## Appeal Decision

**Appeal Ref: APP/T2350/W/24/3355649**

**Riverside Barn Alston Lane, Longridge, Preston PR3 3BN**

- The appeal is made under section 78 of the Town and Country Planning Act 1990 (as amended) against a refusal to grant planning permission.
  - The appeal is made by Mr Adam Richardson against the decision of Ribble Valley Borough Council.
  - The application Ref is 3/2024/0437.
  - The development proposed is retention of garage with integral studio (in roof) not constructed on conformity with planning permission ref no. 3/2020/0199.
-

Description
As Built Elevations and Sections

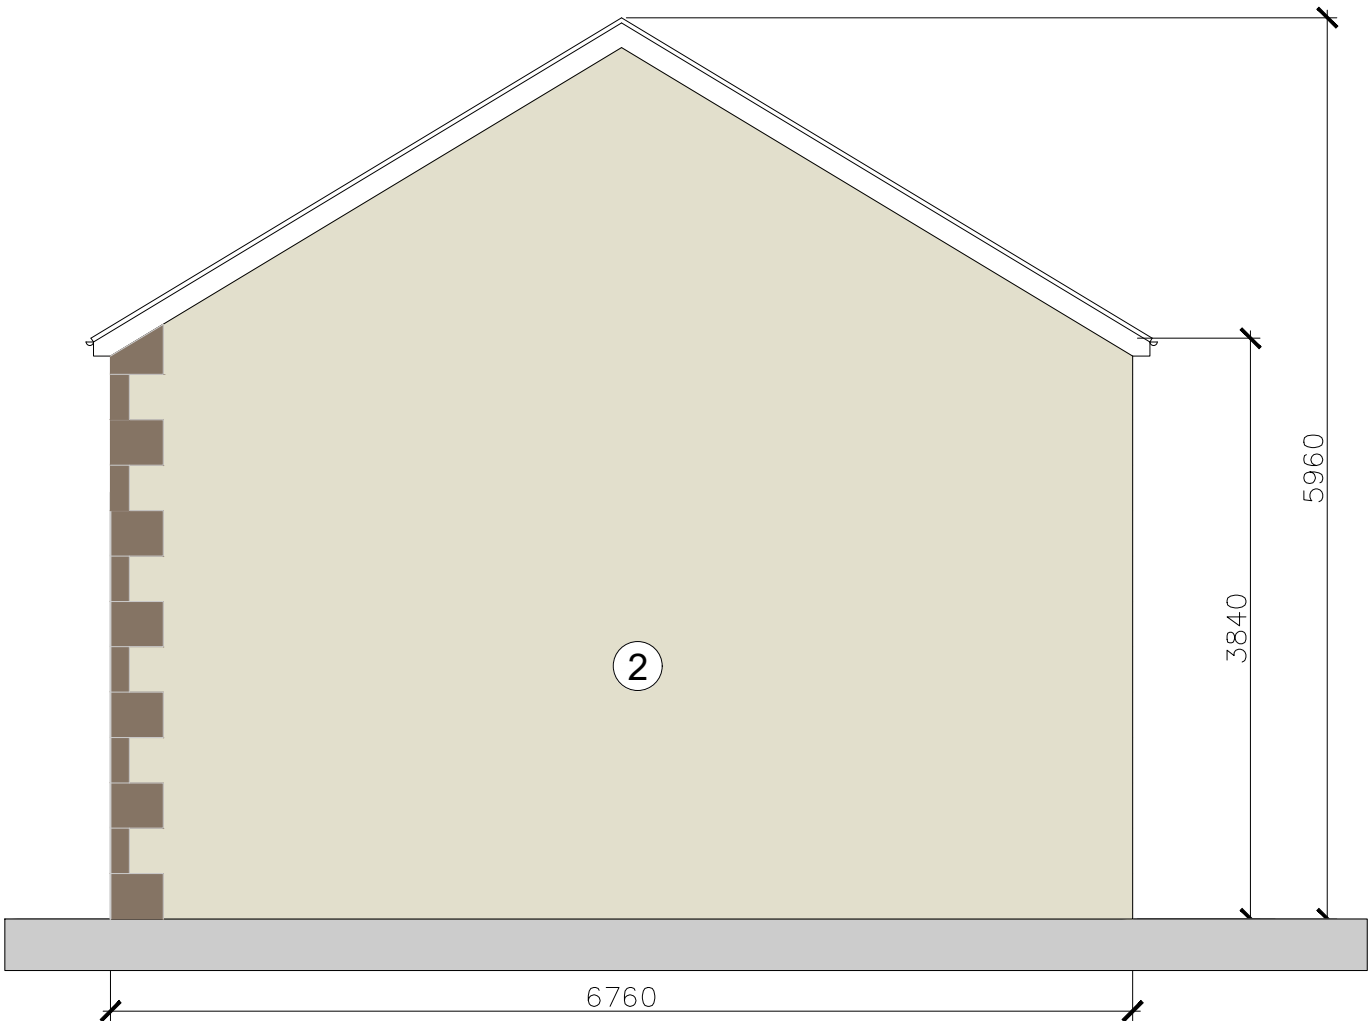
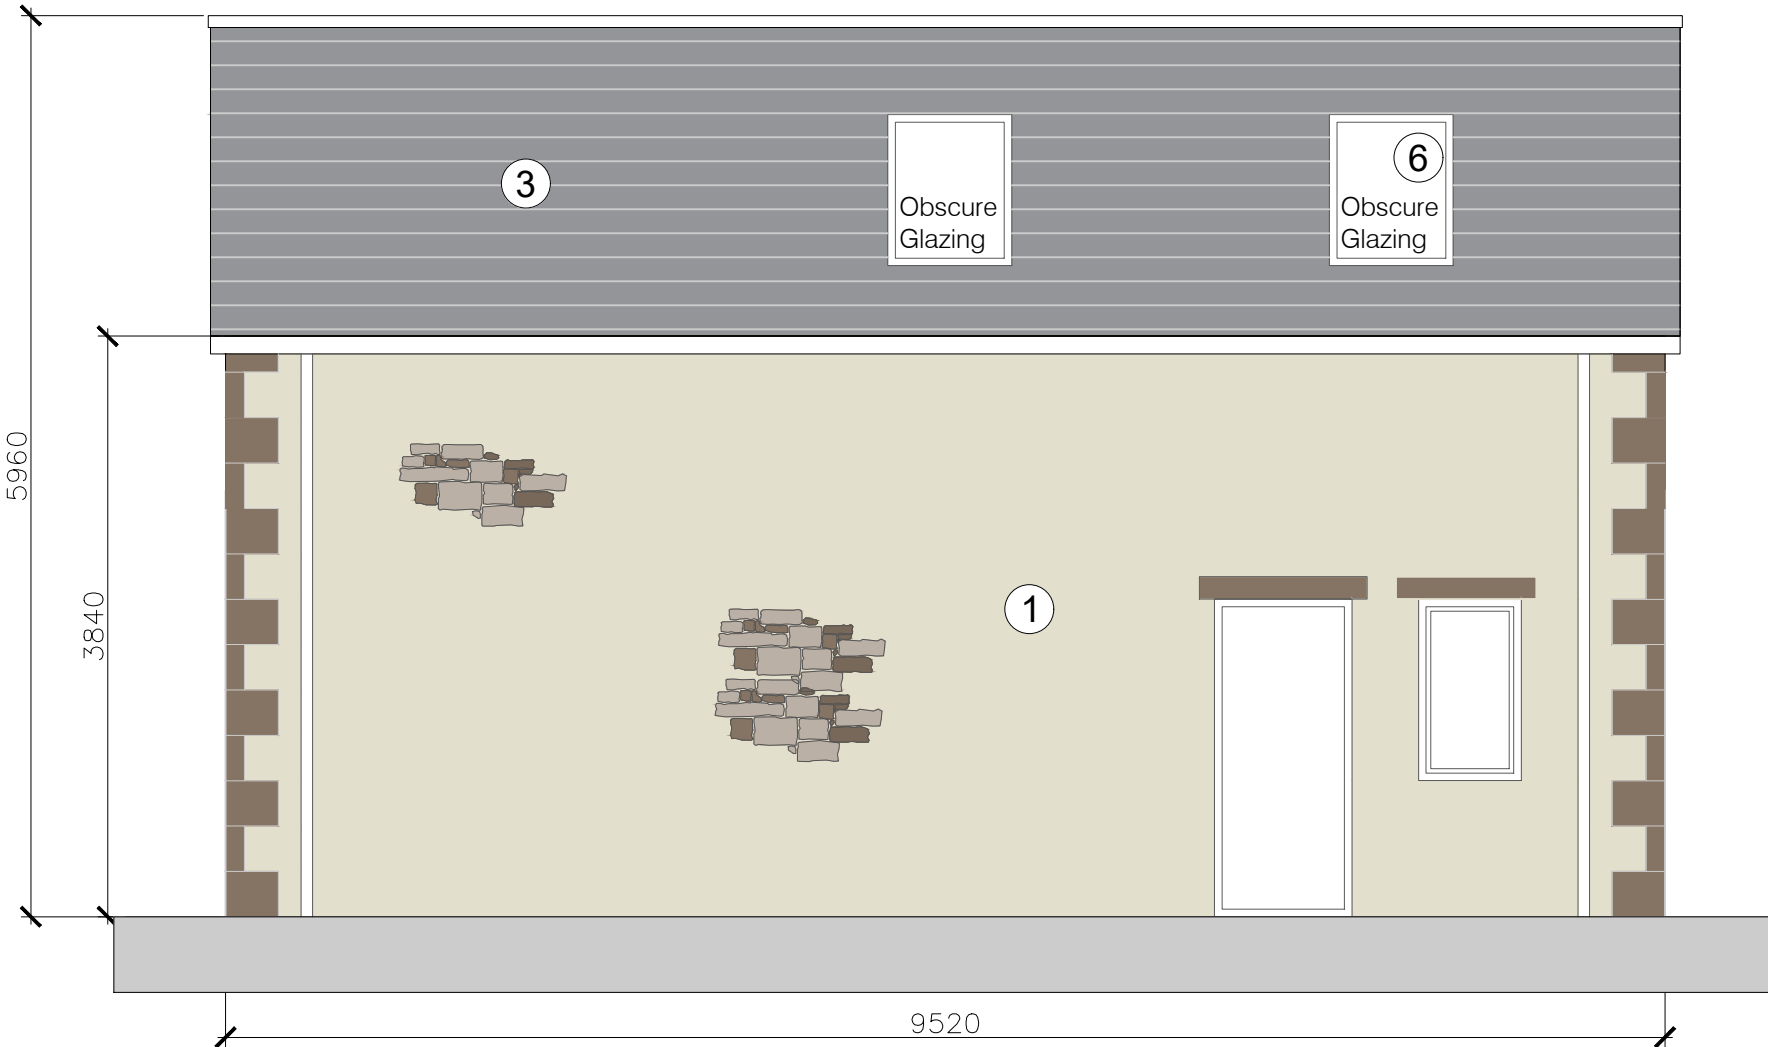
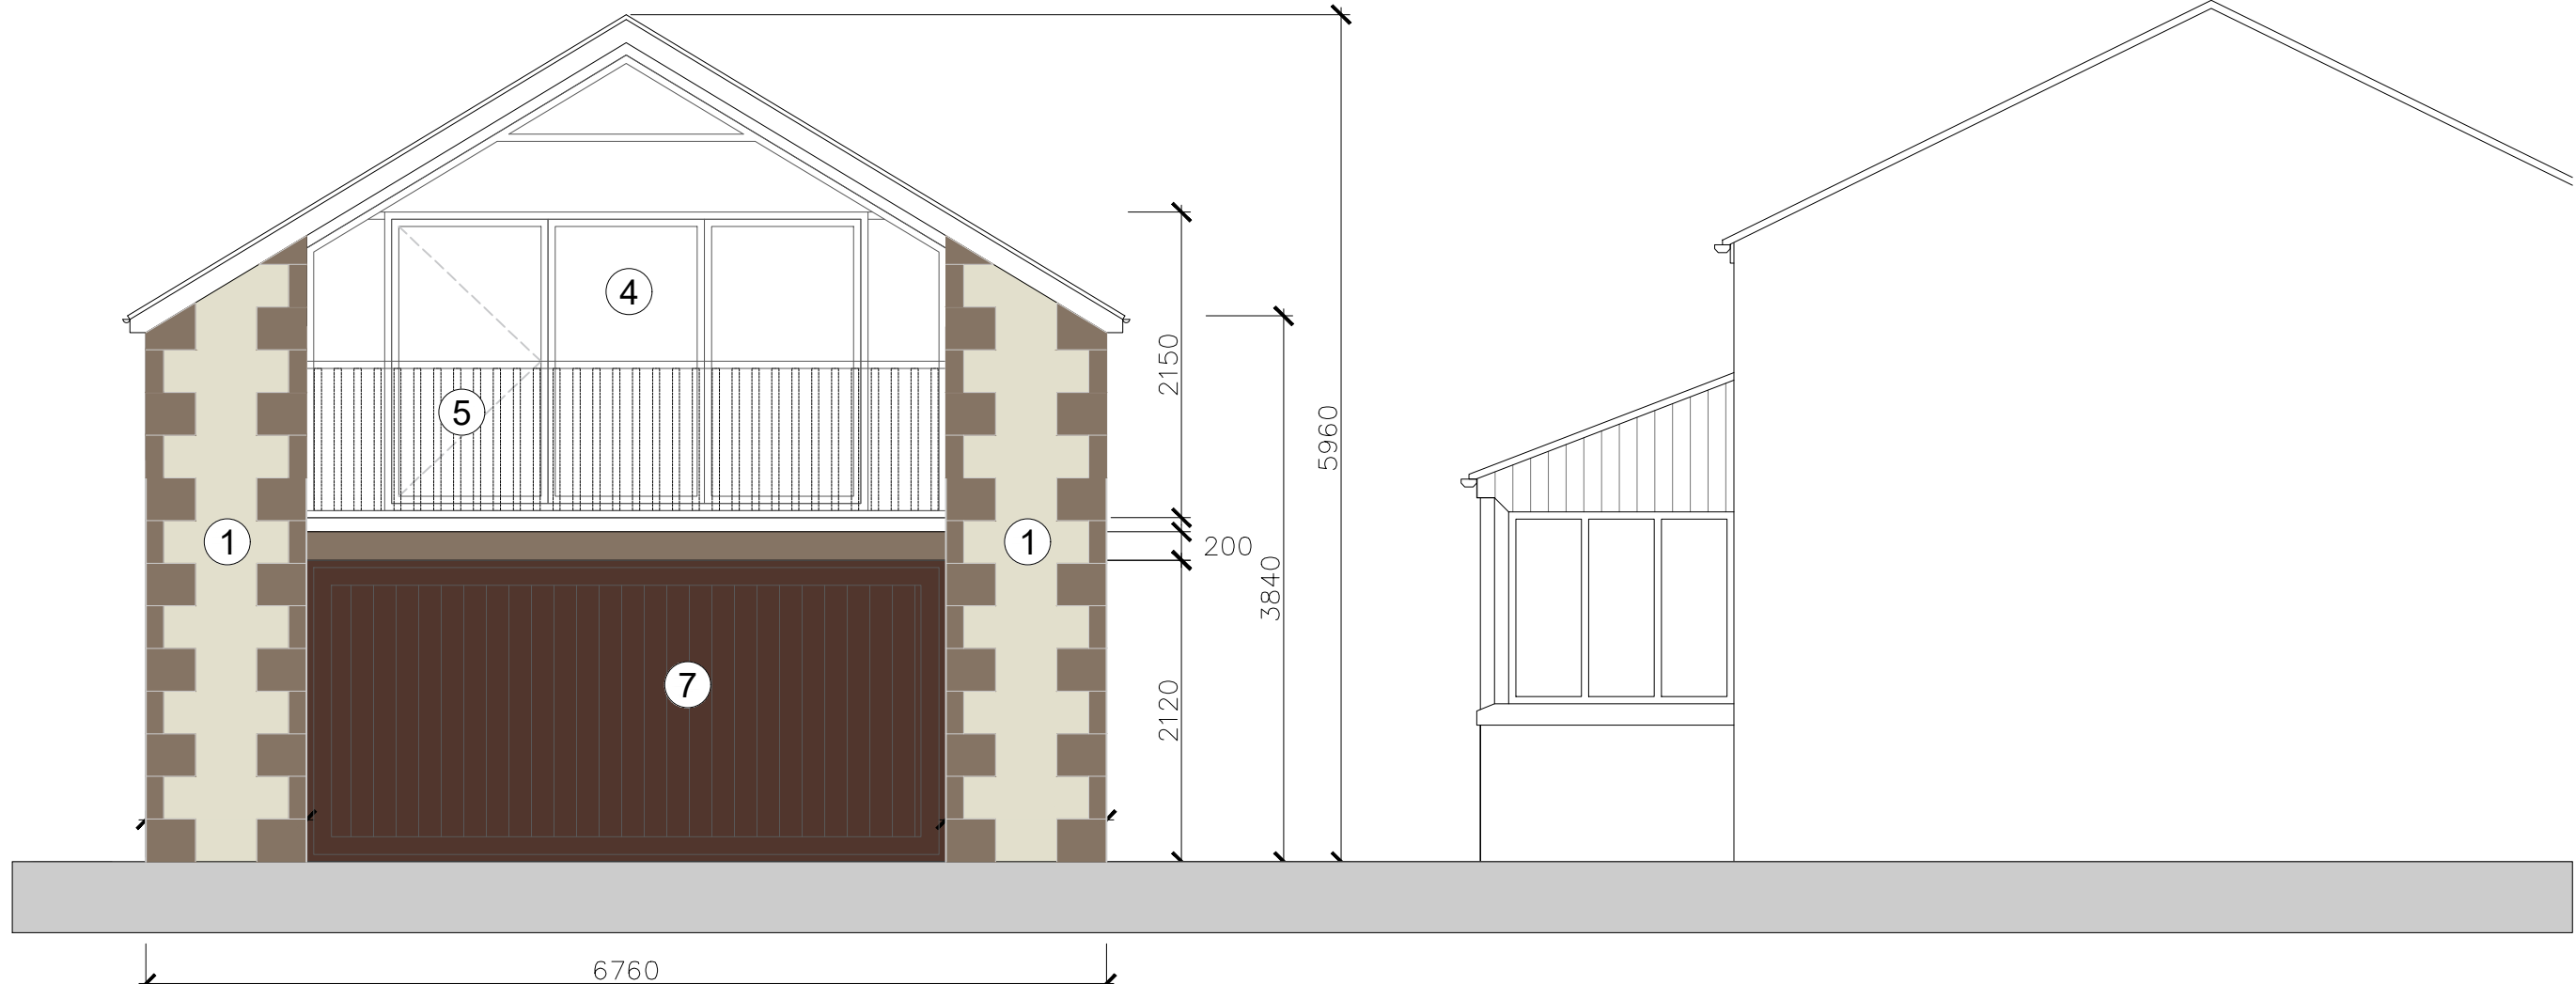
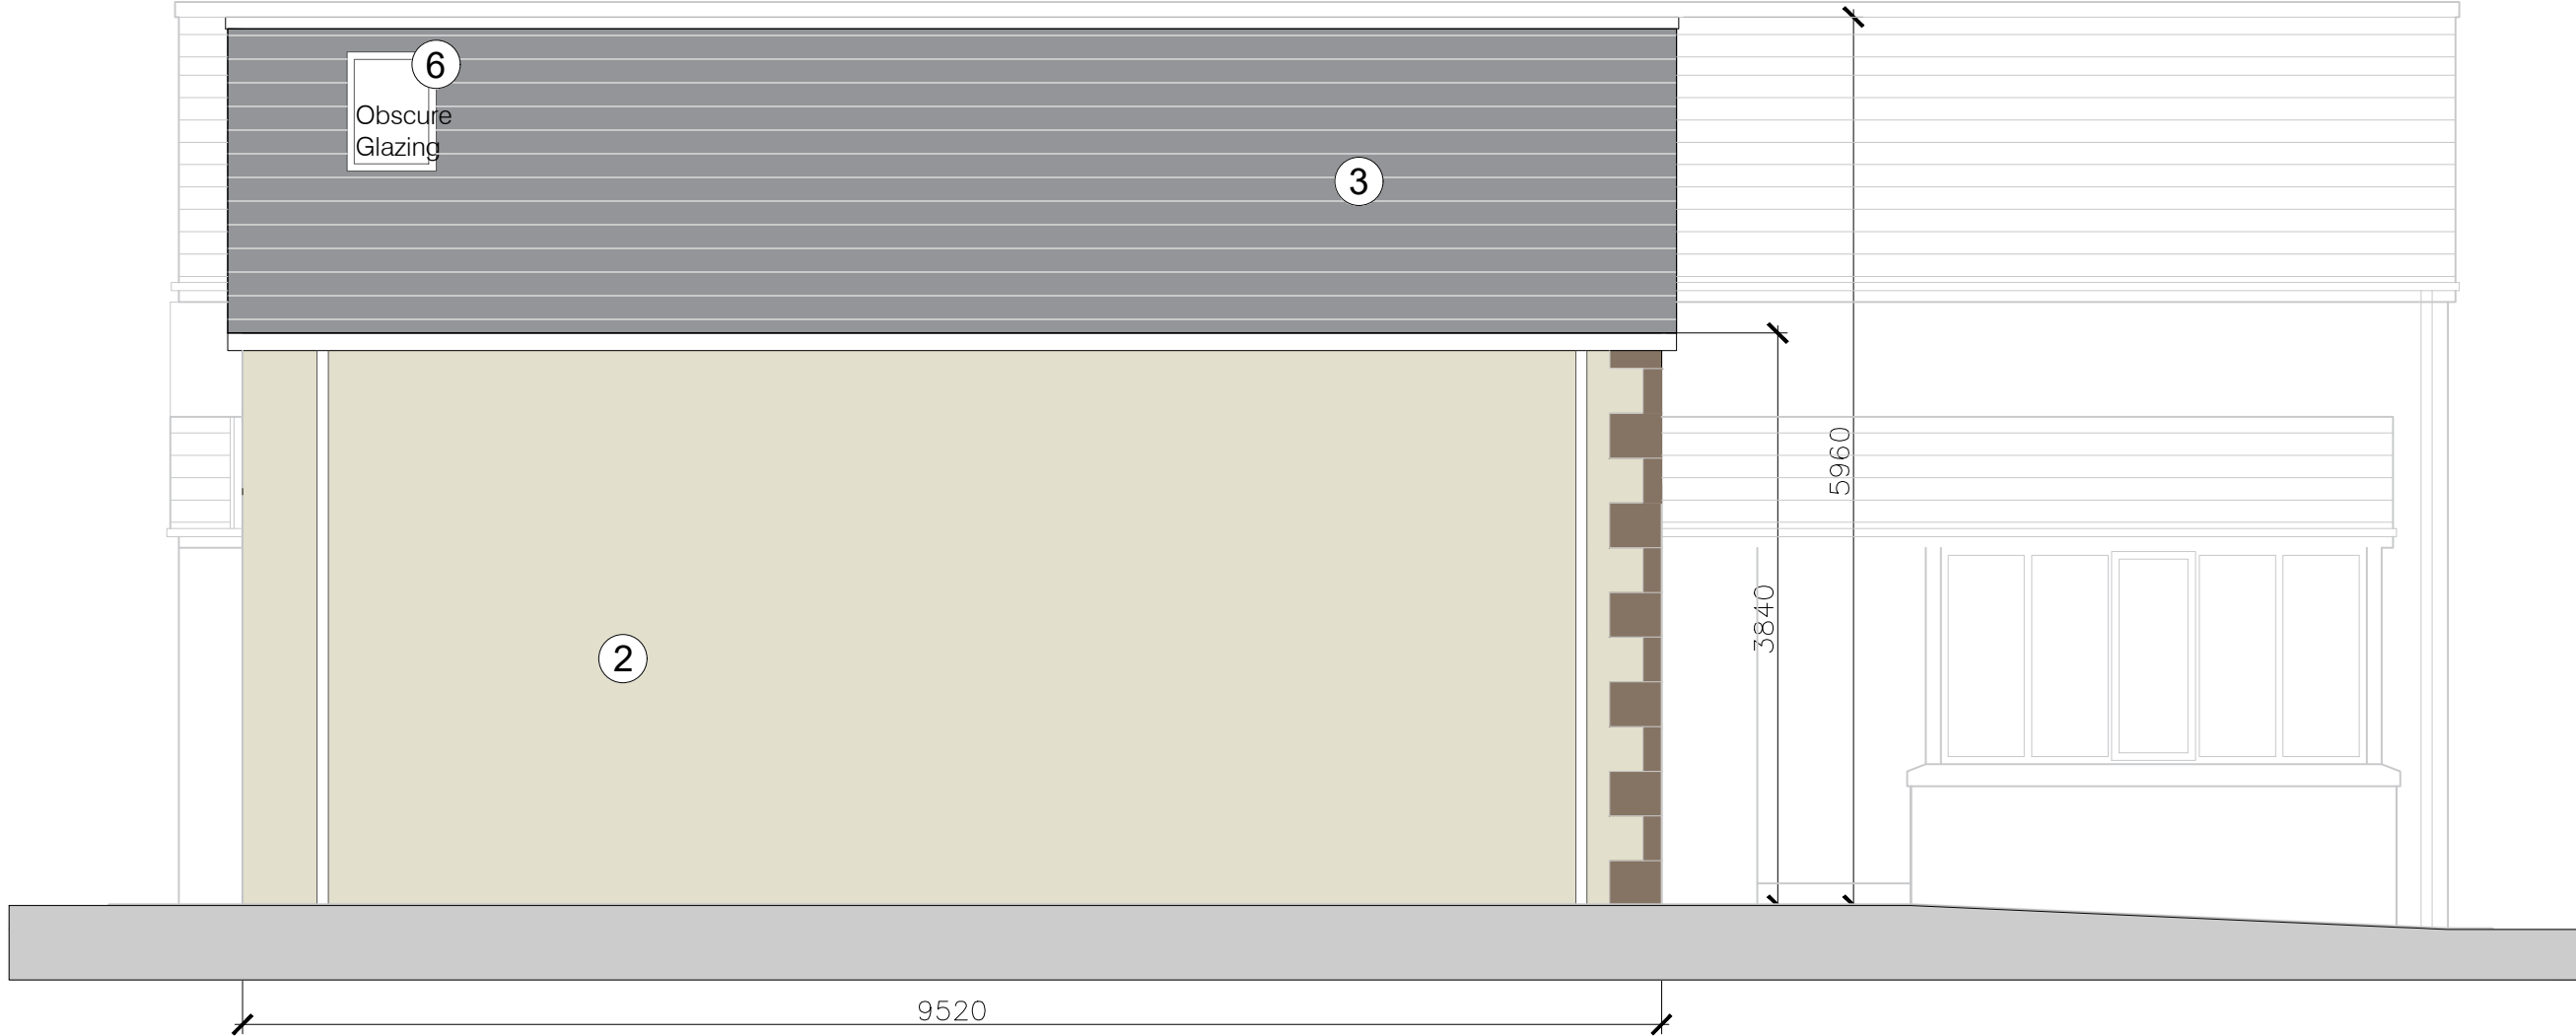
2. Planning permission (Ref 3/2020/0199) was granted in March 2020 for removal of existing conservatory and construction of detached garage with home office above. The permission has been implemented but the building has not been constructed in accordance with the approved plans. The appeal scheme varies in terms of its length, width and height, the inclusion of a Juliet balcony and rooflights, and changes to doors and windows.

6. The proposal would be a detached building finished in render and stone and with a pitched slate roof. It would be roughly 6.7m by 9.5m, with eaves roughly 3.8m tall and ridge line just under 6m. It would be narrowly separated from and parallel to the west side elevation of its host. The building would not be as tall as Riverside Barn, but nevertheless it would be substantially large.

14. The proposal is in roughly the same location as the previously permitted ancillary building. However, the increase in the height of the eaves and the ridge would result in a significant increase in the scale and bulk of the building. The larger gable end and the greater height and thereby extent of side elevation would result in far greater overbearing and overshadowing of the neighbouring dwelling and garden. As the planning permission would not result in the same adverse effects on the neighbours, it does not provide a justification for the appeal.

17. The existing planning permission would be a valid fallback position at this site if the appeal should fail. The appeal building would be around 1m taller to its eaves and the ridge would be around 40cm taller than the fallback. Taking into account its increased size, it would be considerably more bulky than the fallback. By virtue

3 As Built South Elevation
Scale 1:50

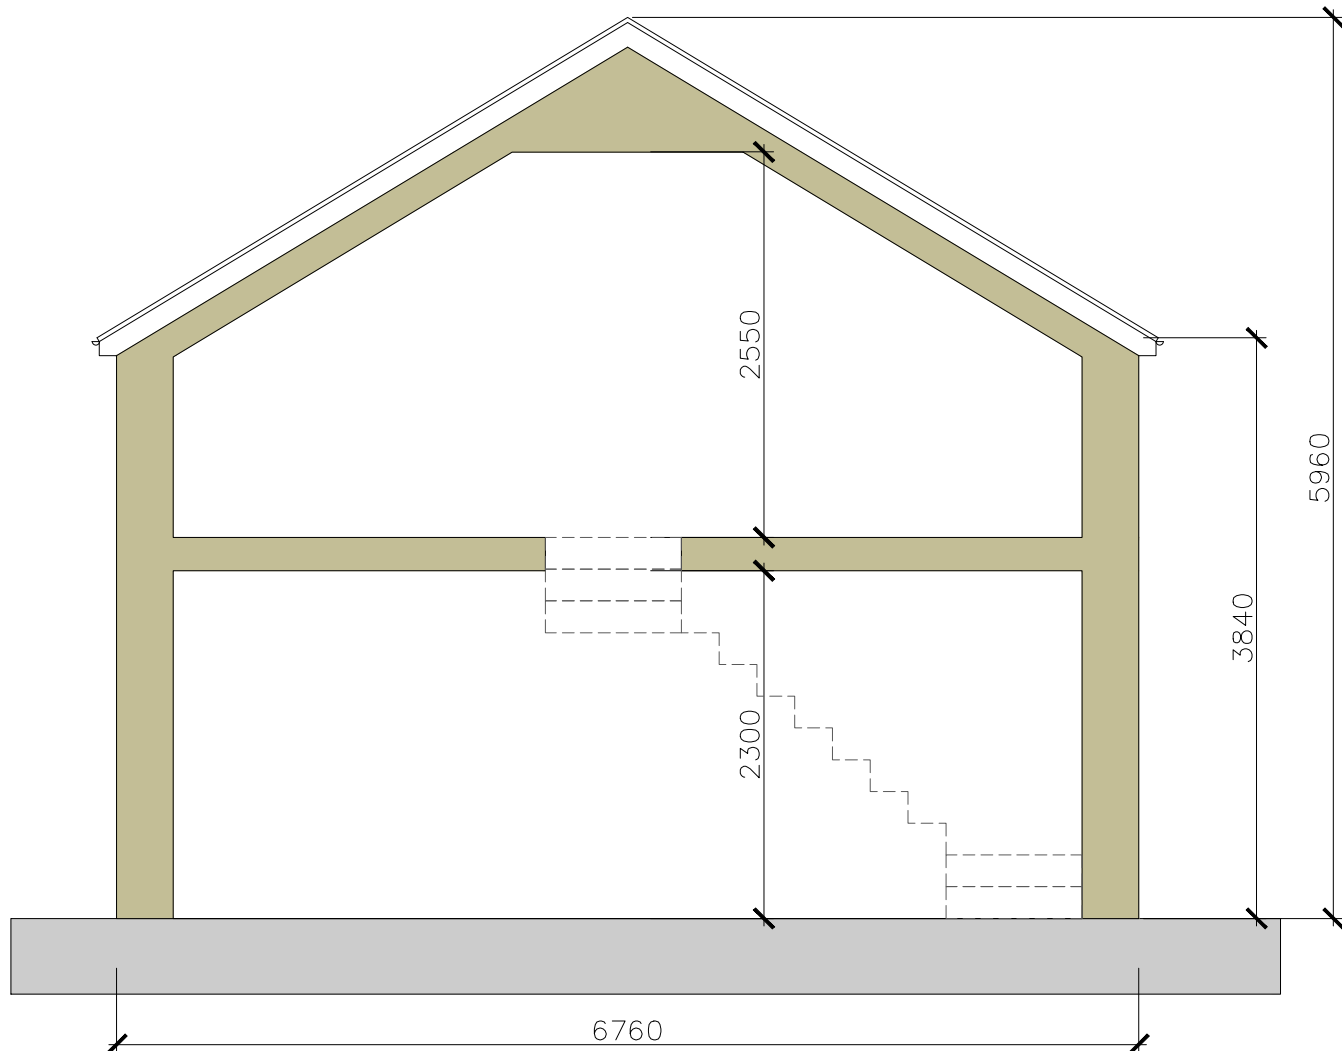
7. The south gable end would feature a double width garage door at ground floor, with extensive glazing and Juliet balcony above. Irrespective that it would be set back from the gable end elevation of its host, by virtue of its large 2-storey scale and extensive glazing the proposal would be a prominent and conspicuous feature. Although set back from the road, the proposal would be readily visible in juxtaposition with its host. The overtly contemporary gable end would be out of keeping with the traditional farmstead building group. The proposal would dominate its setting and it would not be readily interpreted as a subservient ancillary outbuilding. Irrespective of the use of stone and slate, the visually imposing building would not be in keeping with the local vernacular and it would detract from local distinctiveness and sense of place.

10. The extensively glazed gable end with Juliet balcony would face away from the neighbouring properties. Consequently, there would be no overlooking or loss of privacy to the neighbours' gardens or their habitable room windows.

13. The proposal would be south of the garden and south-west of the rear elevation of Beech House. By virtue of its proximity, height and scale, the proposed large gable end would significantly enclose the neighbours' rear garden, overshadow it for part of the day and it would be overbearing to the neighbours' in their private outdoor space. The proposal would be within about 5m of the rear elevation of Beech House. At this distance, its height and scale would diminish the outlook from the closest habitable room windows in Beech House. Moreover, there would be a loss of daylight and sunlight to the closest windows for part of the day and at times of year when the sun is lower in the sky. These various impacts would be cumulatively detrimental to the neighbours' residential amenity.
